Our ref: NO/2019/112110/01-L02
Your ref: 3/2019/0840
Date: 23 October 2019

**EXTENSION TO EXISTING WORKSHOP AND CREATION OF PARKING AREA.
JAMES ALPE LIMITED LINCOLN WAY, CLITHEROE, LANCASHIRE, BB7 1QD.**

Environment Agency position

PROPOSED SITE PLAN			
Site: Vehicle Repair Centre - Workshop Extension Lincoln Way Clitheroe			
Client: James Alpe			
Date: 24.09.19		Scale: 1:500/50 @ A2	
Project No: ALP/21 - Dwg 03		Drawn: AxK	
Amendments:

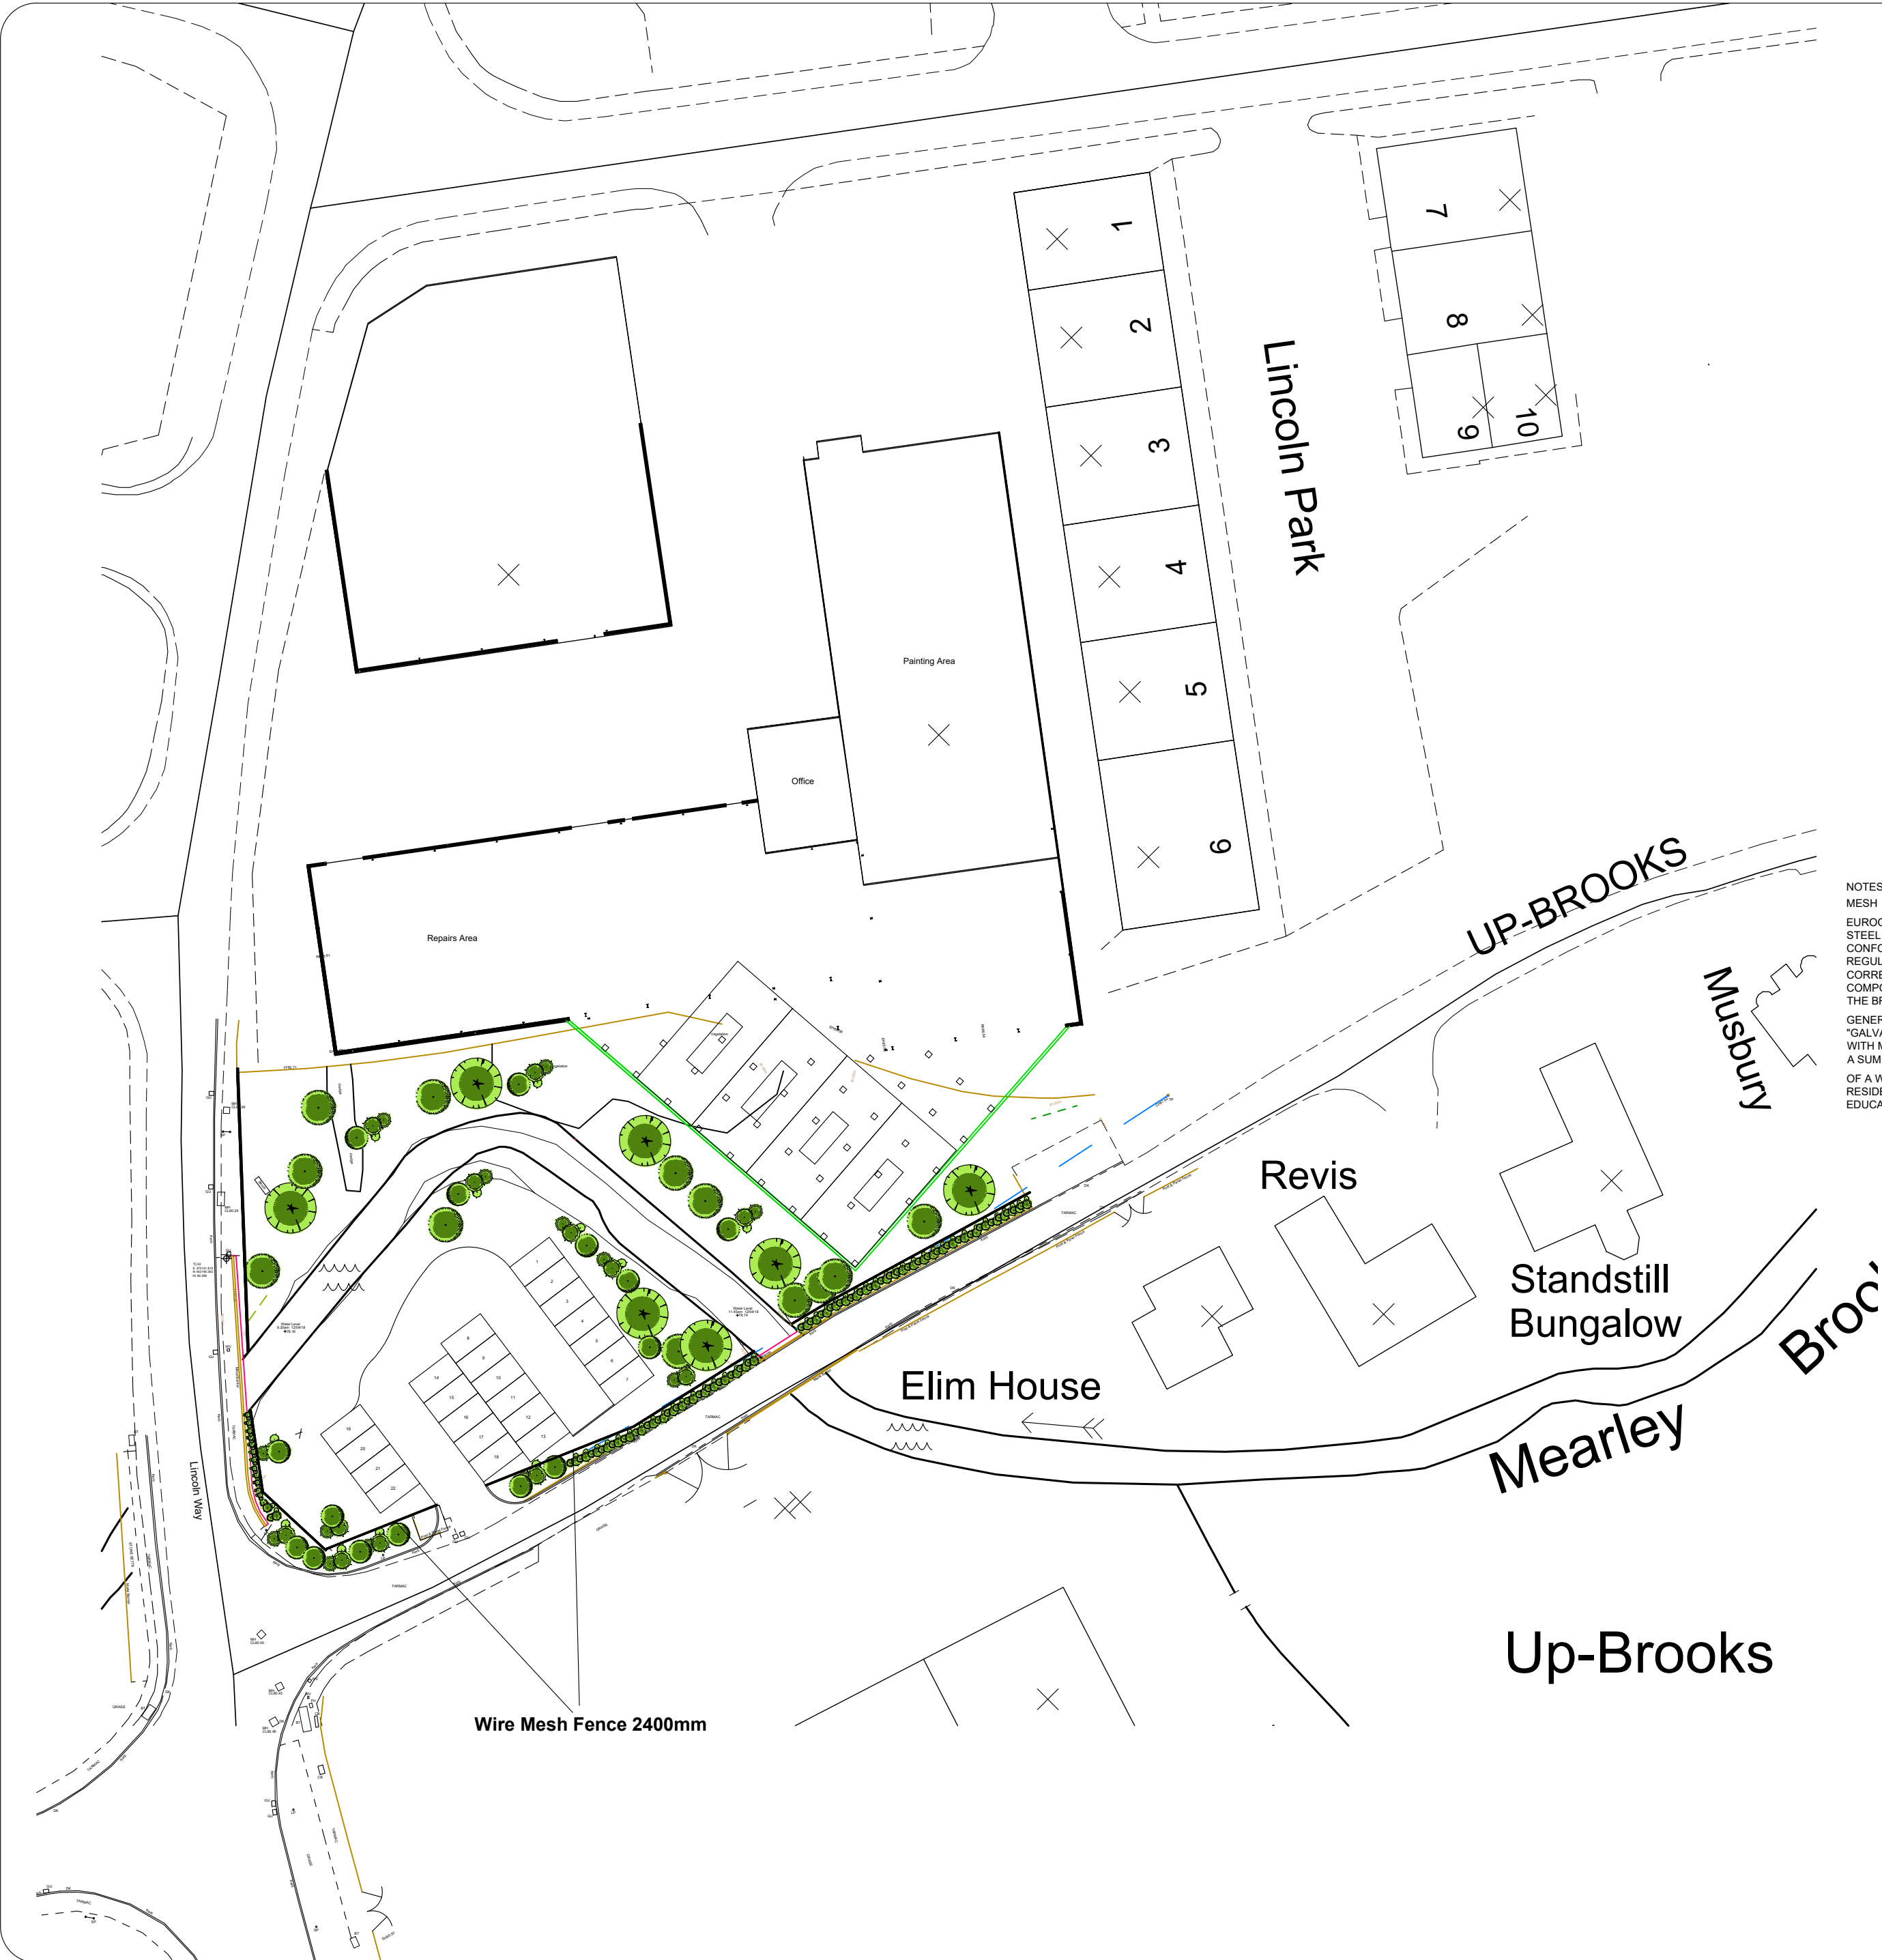
Due to the absence of an acceptable Flood Risk Assessment (FRA) and the proposal to erect a fence and provide car parking within 8 metres of a Main River, we object to this application and recommend that planning permission is refused. As submitted, it is unlikely that we would grant a flood risk activity permit for this application

- * Properly assess the increased flood risk associated with infilling the floodplain. The proposed car park within the floodplain will reduce the flood storage capacity of the river and will increase flood risk to adjacent properties. Infilling the floodplain will only be permitted if compensatory flood storage is provided and flood risk is not increased.
- * Properly understand and assess the risks of erecting wire mesh fencing within the floodplain and next to the river. The proposed fencing will impede overland flood flow which will increase flood risk to adjacent properties.
- * take the impacts of climate change into account
- * consider how people will be kept safe from the identified flood hazards
- * consider how a range of flooding events (including extreme events) will affect people and property
- * consider the requirement for flood emergency planning, including flood

- * The proposed development would restrict essential maintenance and emergency access to the Main River watercourse. The permanent retention of a continuous 8 metre wide unobstructed area is an essential requirement for future maintenance and/or improvement works.
- * The proposed development would obstruct flood flows, thereby increasing the risk of flooding to adjacent properties
- * The construction of the car park adjacent to the river may interfere with natural geomorphological processes and could be placed at risk of damage arising from channel migration/erosion.

To overcome our objection, the applicant should submit a revised FRA which addresses the points highlighted above.
